Application for removal or variation of a condition following grant of  
planning permission. Town and Country Planning Act 1990.  
Planning (Listed Buildings and Conservation Areas) Act 1990

Number	<input type="text" value="266"/>
Suffix	<input type="text"/>
Property name	<input type="text"/>
Address line 1	<input type="text" value="Peterborough Road"/>
Address line 2	<input type="text"/>
Address line 3	<input type="text"/>
Town/city	<input type="text" value="Whittlesey"/>
Postcode	<input type="text" value="PE7 1PJ"/>
Description of site location must be completed if postcode is not known:	
Easting (x)	<input type="text" value="524685"/>
Northing (y)	<input type="text" value="297208"/>
Description	<input type="text"/>

Wish to amend the approved plans listed within this condition to replace a window on the rear with doors and Juliet balcony.

Project Proposed 2-Storey Rear and Single Storey Front Extension		
Drawing Title Proposed Elevations		
Address 266 Peterborough Road, Whittlesey		
Drawn By A. L. Sutton	Paper Size A3	Date March 2021
Project Name 017	Drawing Number 004	Revision A

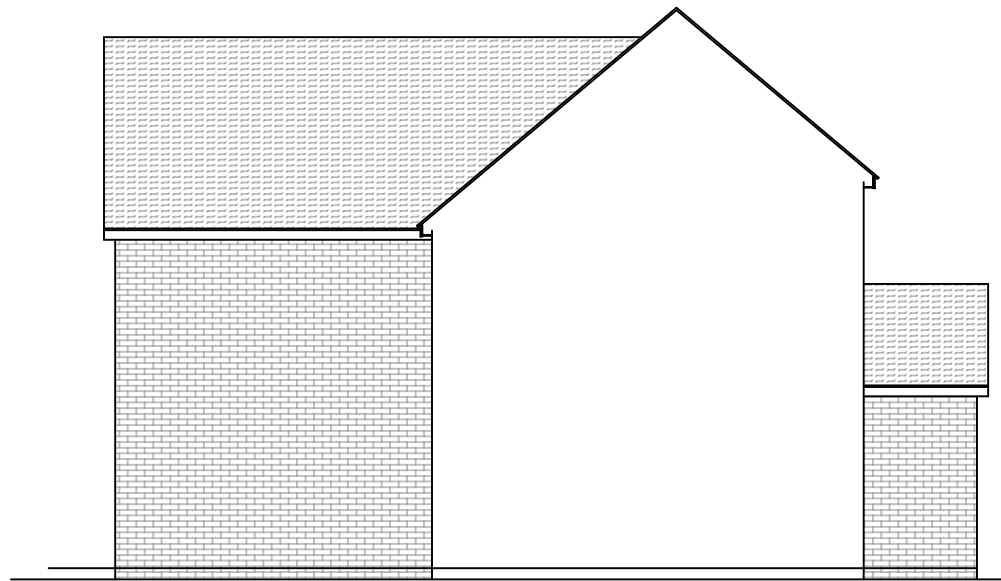
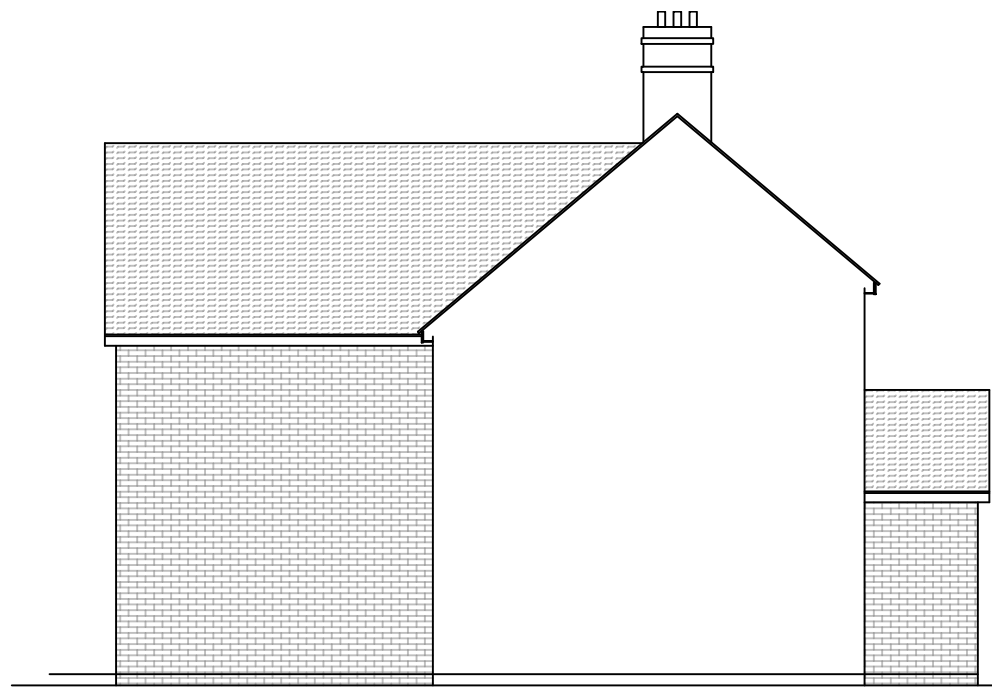
017-003 - Proposed Floor Plans to be replaced with 017-003 - Proposed Floor Plans - Rev A  
017-004 - Proposed Elevations to be replaced with 017-004 - Proposed Elevations - Rev A
